An Bord Pleanála

Councillor Donna Cooney

Observations planning reference 2861/21

2861/21

**Figure 10.1:** IES Geometric Model of Dublin Central Masterplan and surrounding context.

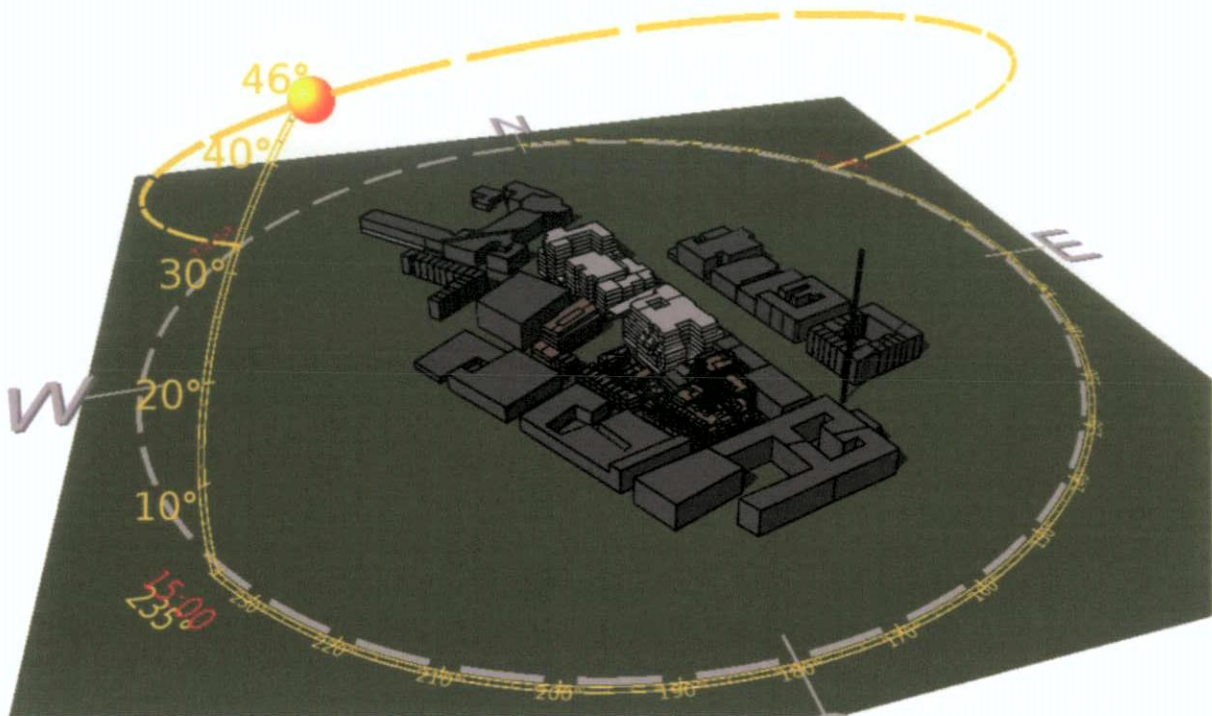
In the applicant response -Site 5 sunlight Analysis by BDP Diarmuid Reynolds and Patrick Kavanagh; the Geometric Integrated Environmental Solutions model of the baseline site would appear to be devoid of almost any daylight ref..Figure 2 pg 8 of report
